Town & Country Planning Act 1990 (as amended)
Town and Country Planning (Development Management Procedure) (England) Order 2015
Approval of details reserved by condition imposed under ref APP/C3810/W/19/3241407 (AL/62/19/PL)
relating to Condition Nos 3 - surface water drainage and 4 - protection of retained trees & boundary
vegetation.
Land to South of Sundown Littleheath Road Aldingbourne BN18 0SR

Arun District Council have decided to **REFUSE details reserved by condition for the following reasons:**
The Council Drainage Engineers have objected to the discharge of this condition on the grounds that the further information is required.

DRAWING TITLE
Proposed Site Plan
Storm Drainage

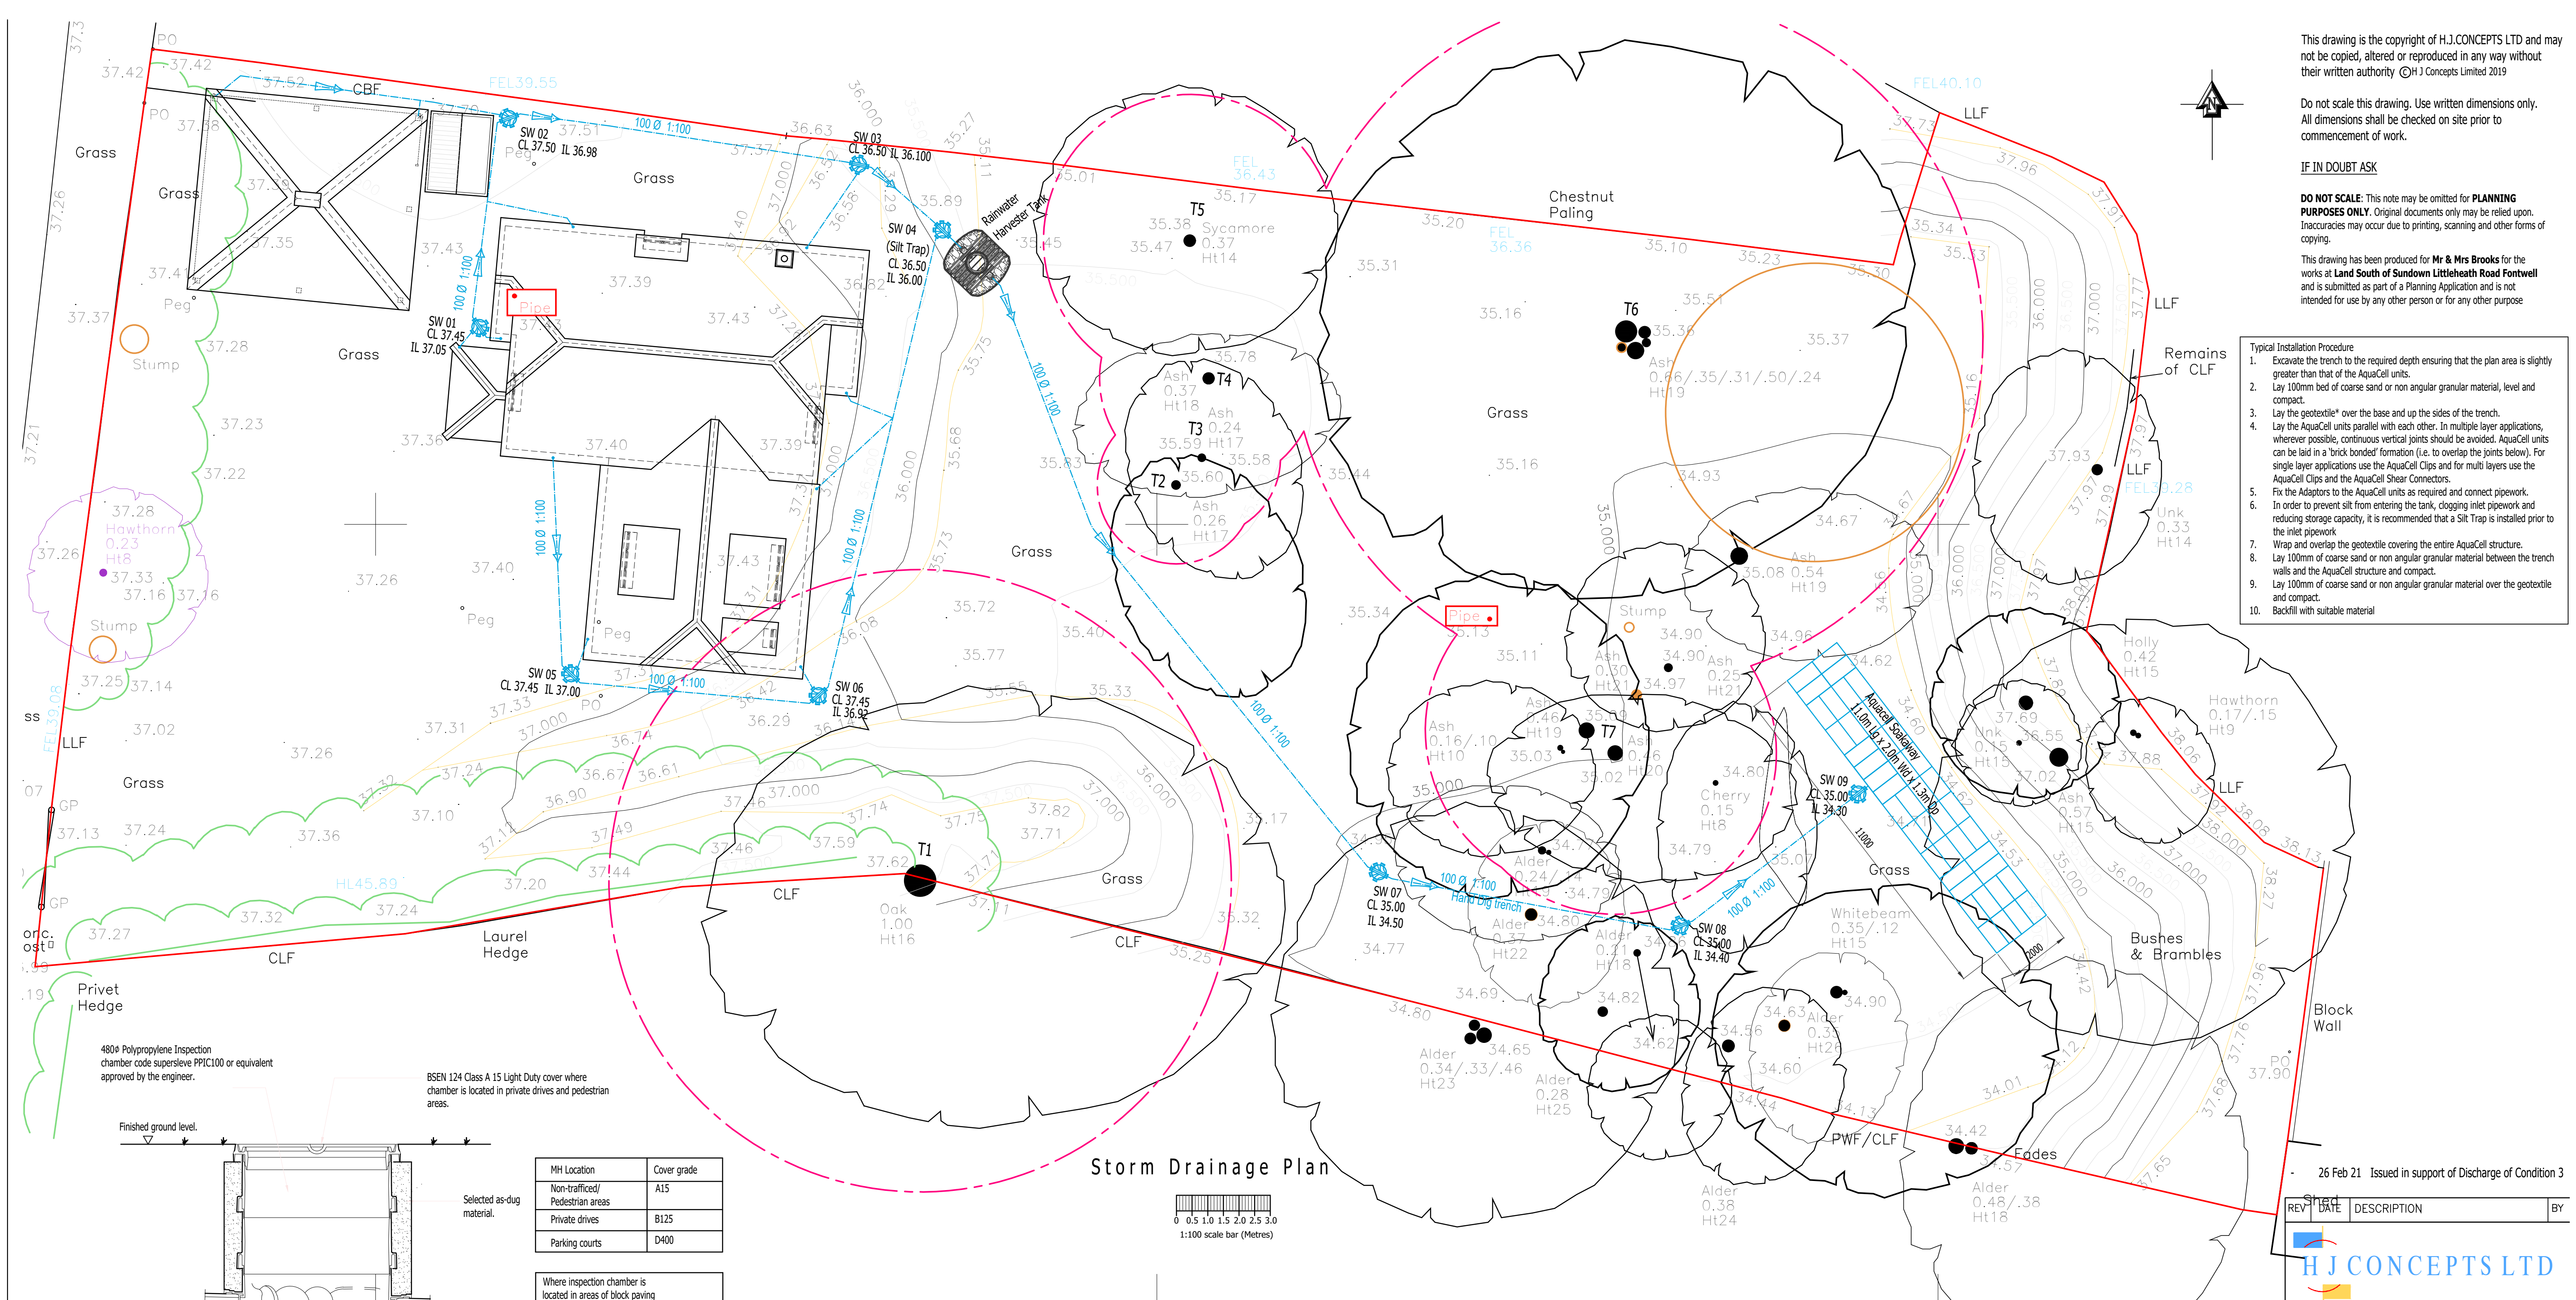
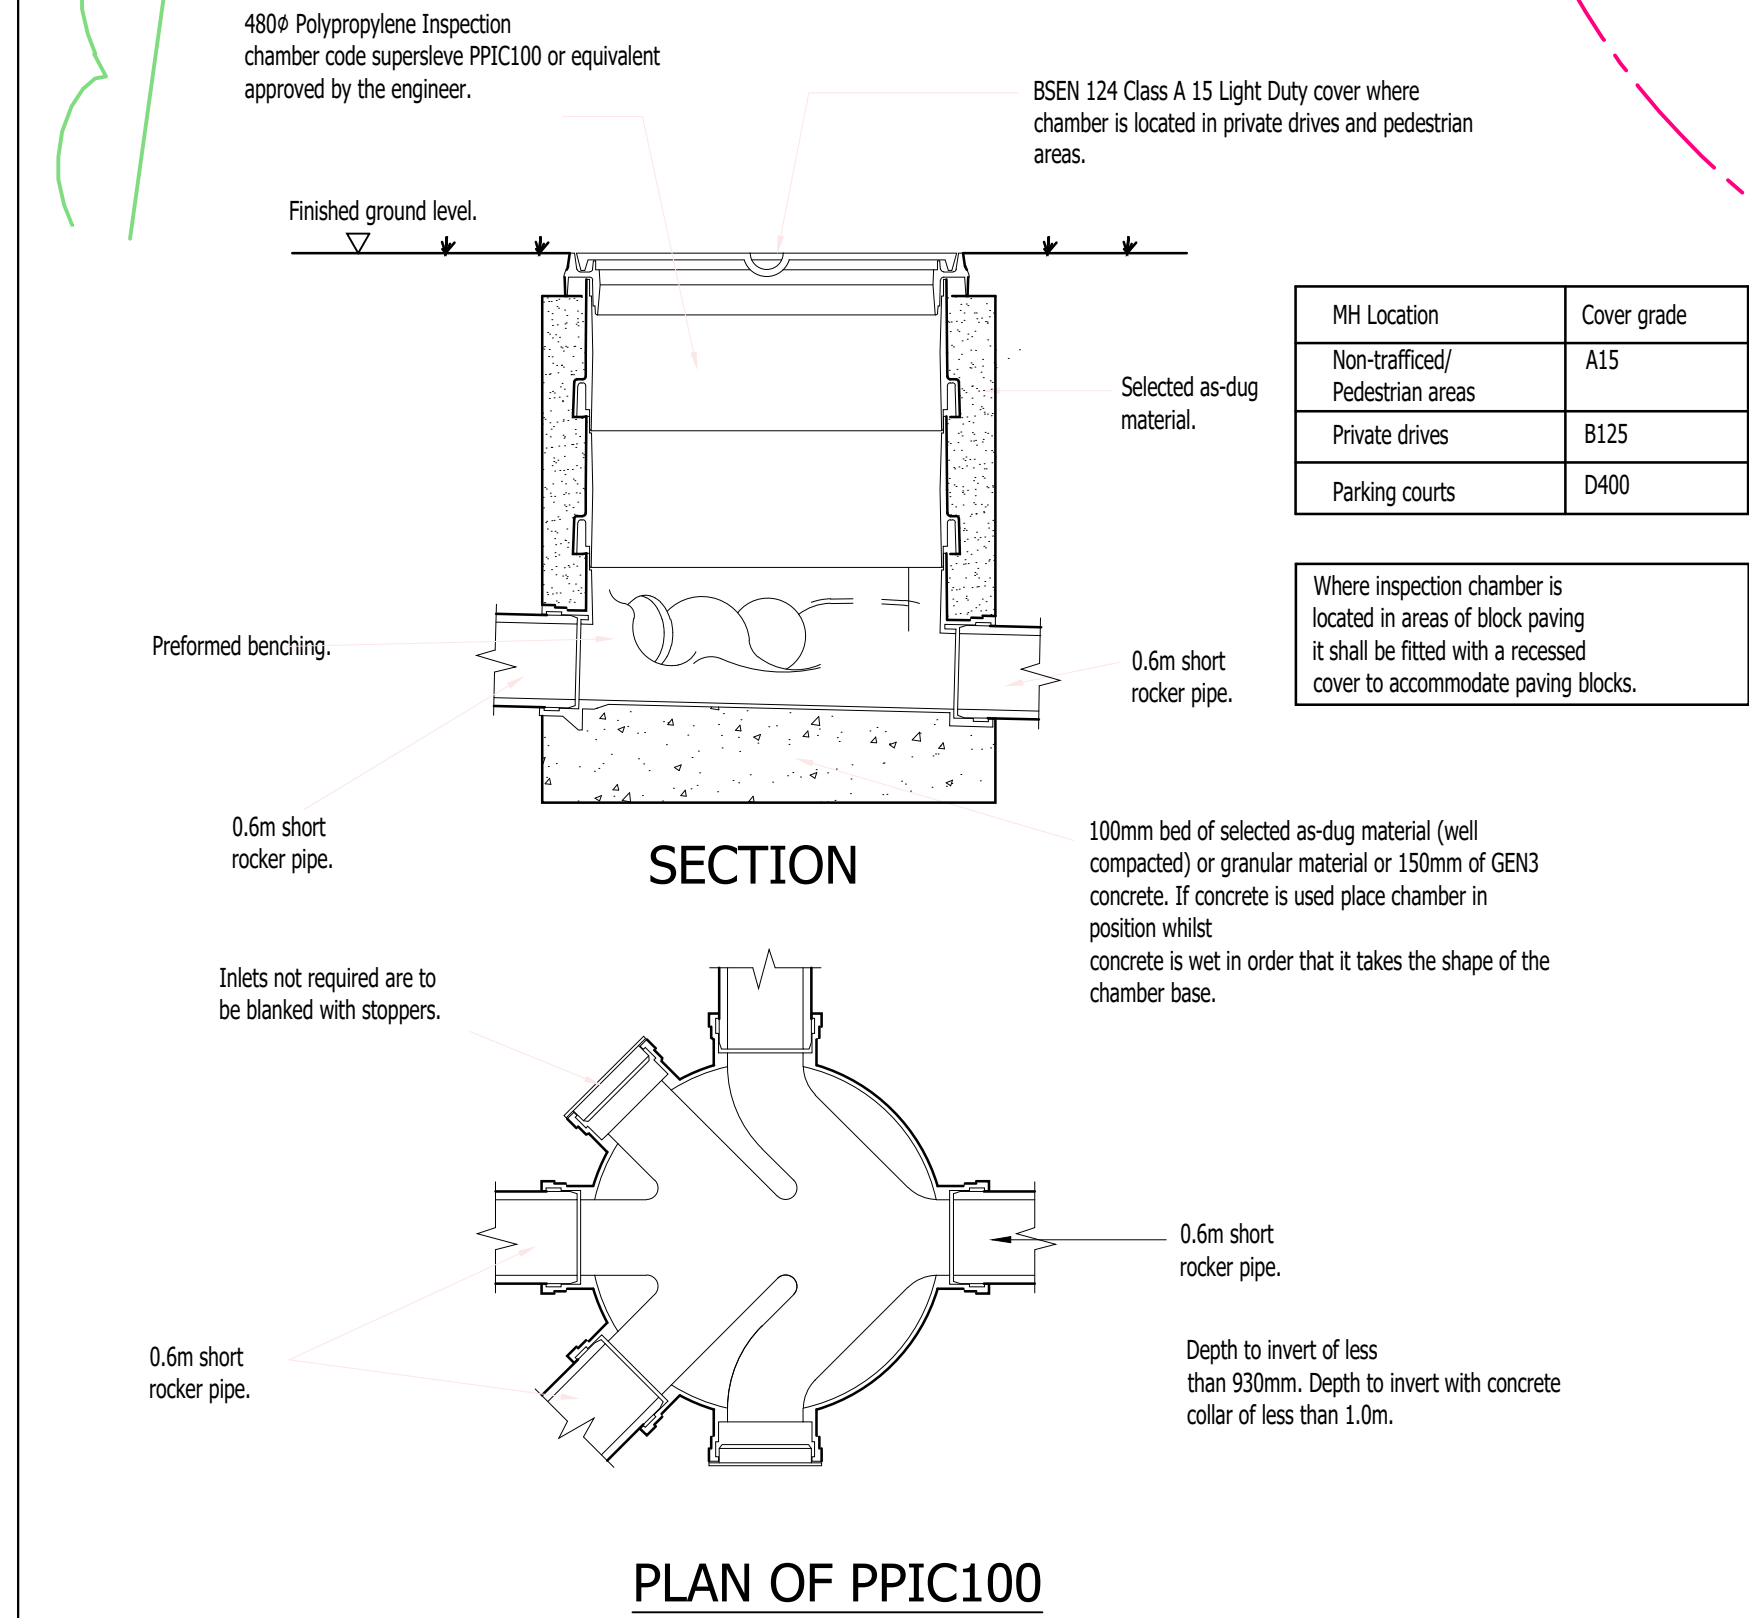
The consultation response dated 20/04/21 indicates the requirement of further amendments and information since the provided information has been considered by Council Drainage Engineers as not sufficient to discharge condition 3. In addition, in their comments Drainage Engineers point out that the surface water drainage design appears to be in direct conflict with submitted arboricultural report.

For the above reason the condition cannot be discharged and you will need to make a revised submission.
